Rezoning Transportation Analysis
Petition Number: Insert Zoning Petition #2020-184
General Location Identifier: 06703101

Revision Log:	Date	Description
	01-21-2021	First Review (KP)
	02-10-2021	Second Review (KP)

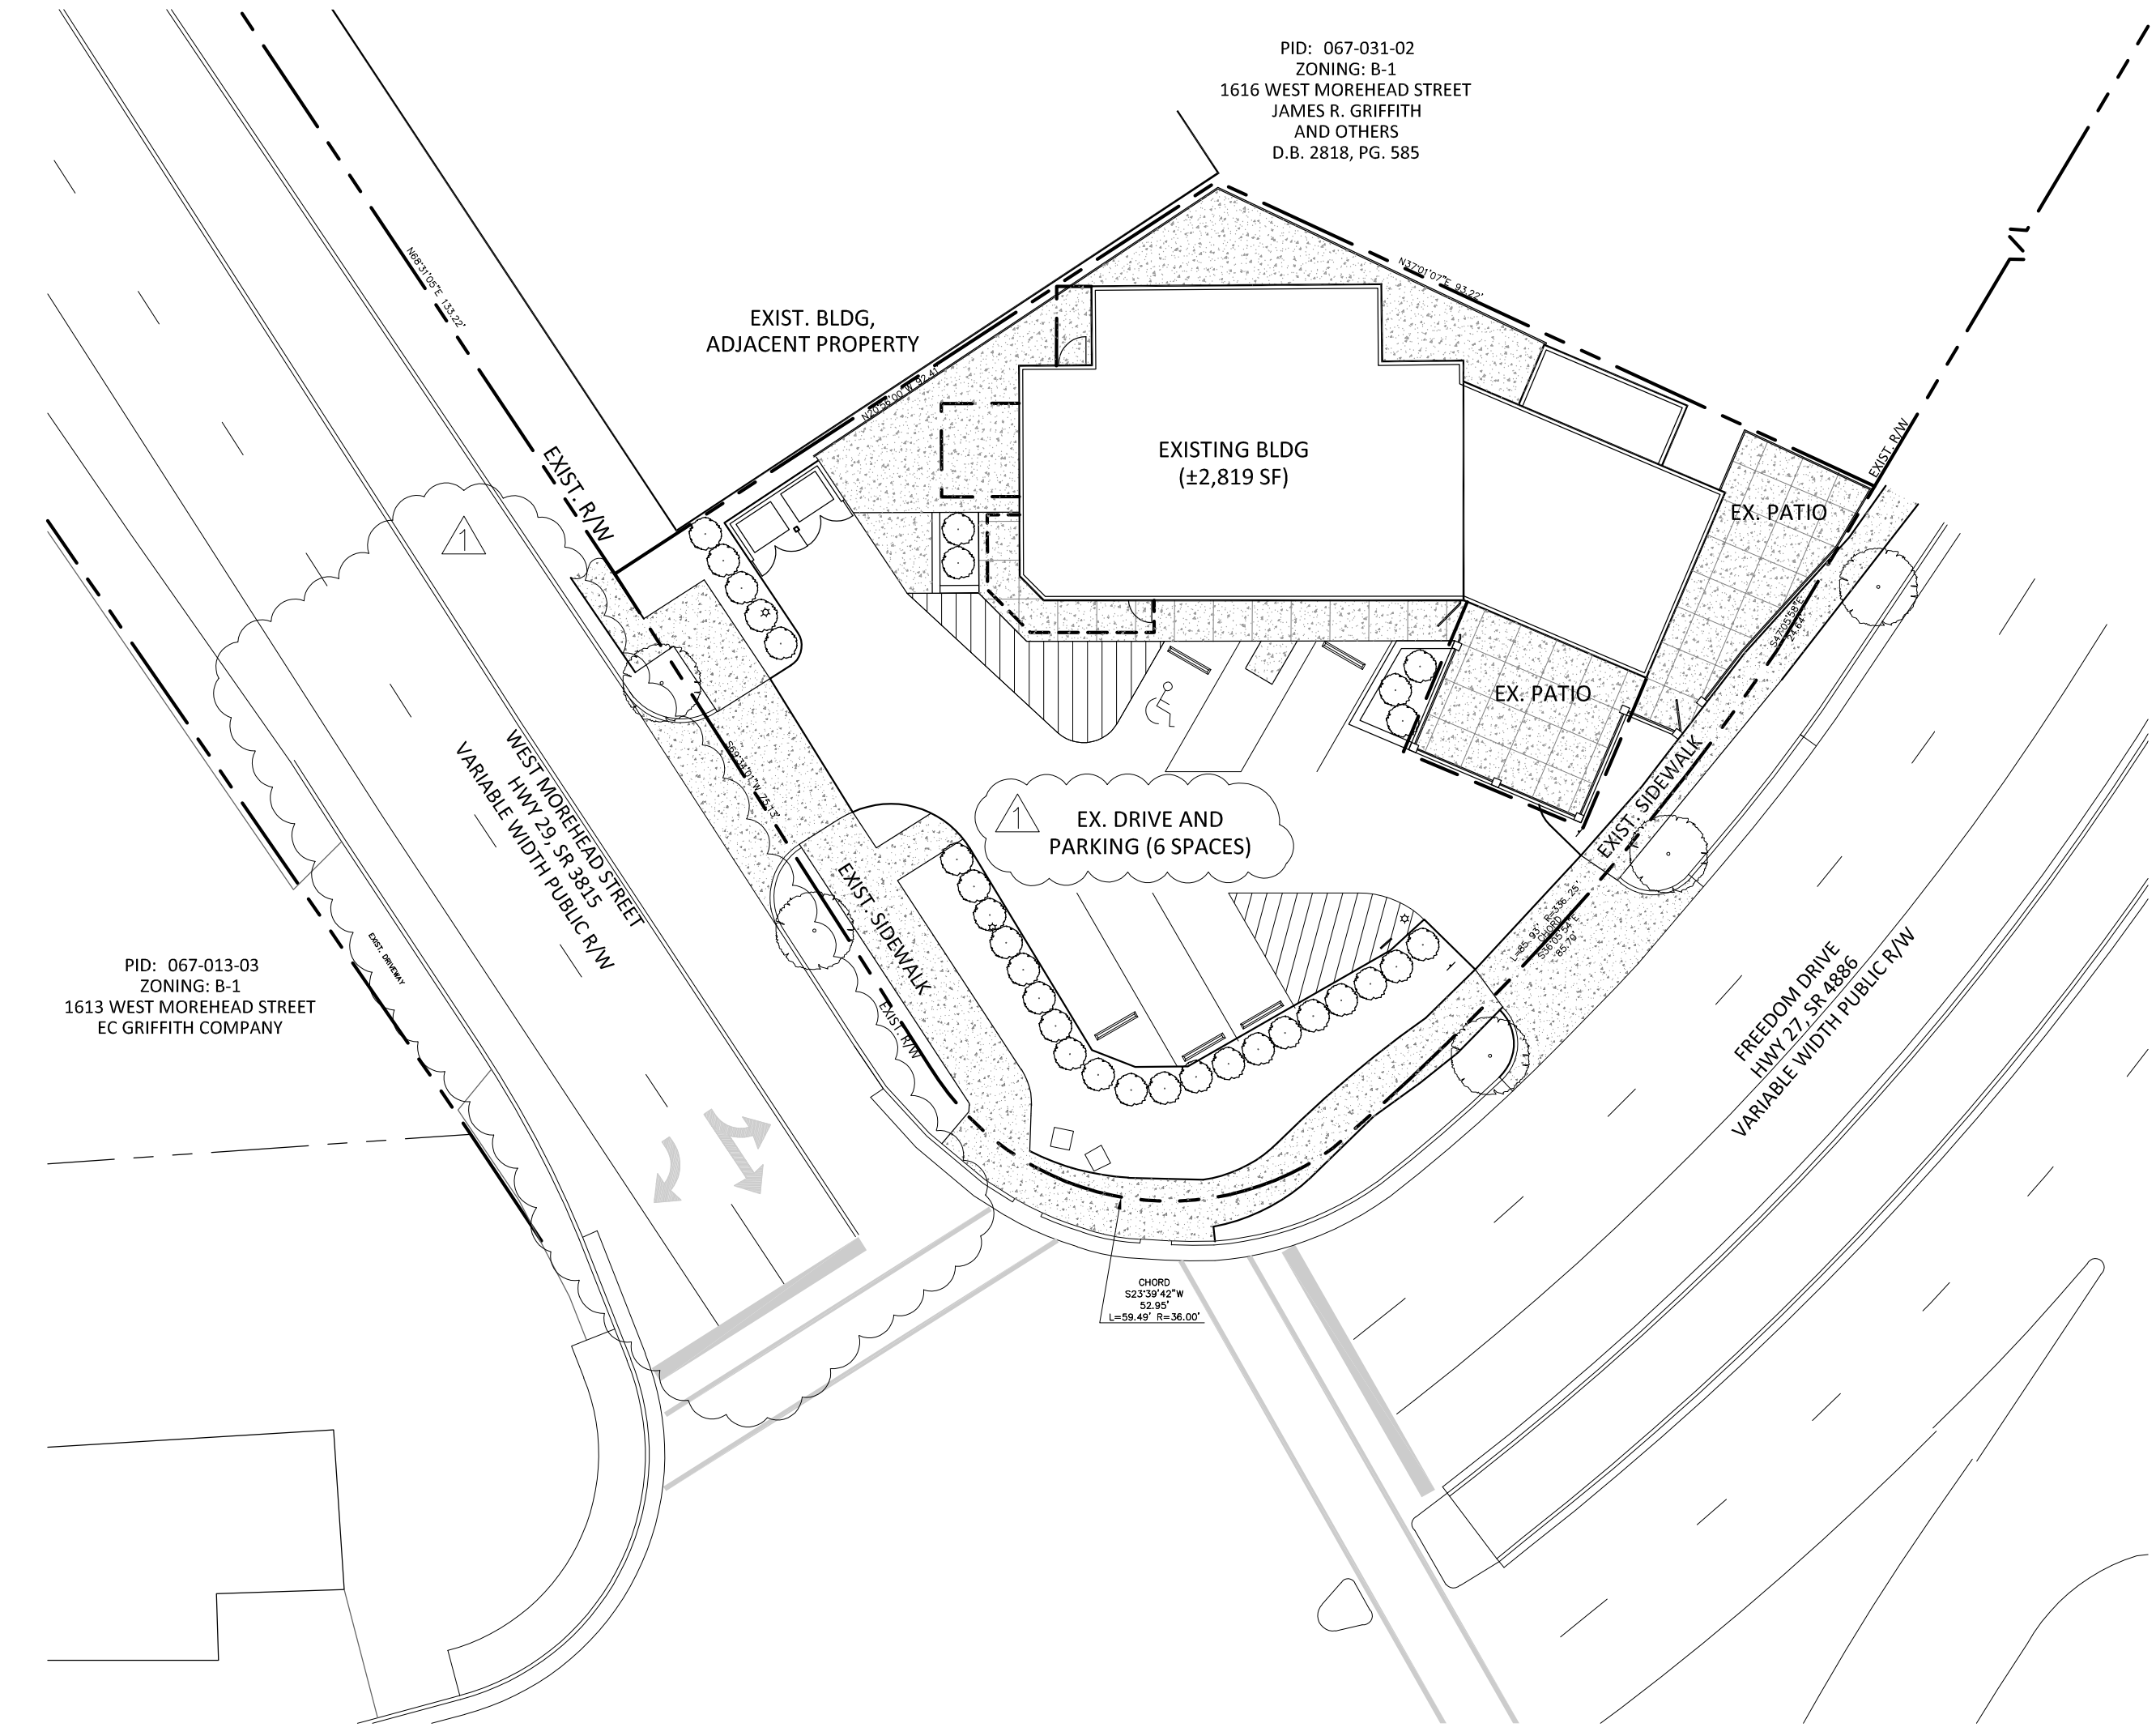
1. Revise the site plan by adding a sidewalk utility easement 2-feet behind the sidewalk along the site's Morehead Street and Freedom Drive frontage.

Update to Comment from 02-08-2021 Site Plan: Please change the language on Transportation Note 2 to "The petitioner will provide an easement to CDOT and NCDOT, as generally depicted on the site plan, for a 2-foot wide area behind and coterminous with the existing sidewalk along both West Morehead Street and Freedom Drive for sidewalk maintenance and underground utilities.". Additionally, please clearly show and label the SUE on the site plan.

2. Revise the site plan by correcting the West Morehead Street pavement markings.

Update to Comment from 02-08-2021 Site Plan: Please include all pavement markings.

⚠ The Petitioner will provide an easement to either the City of Charlotte or to NCDOT, whichever has jurisdiction, for a 2' wide area behind and directly coterminous with the existing sidewalk along both West Morehead Street and Freedom Drive for sidewalk maintenance and for underground utilities ~~except where such easement would encroach upon the existing development on the site.~~
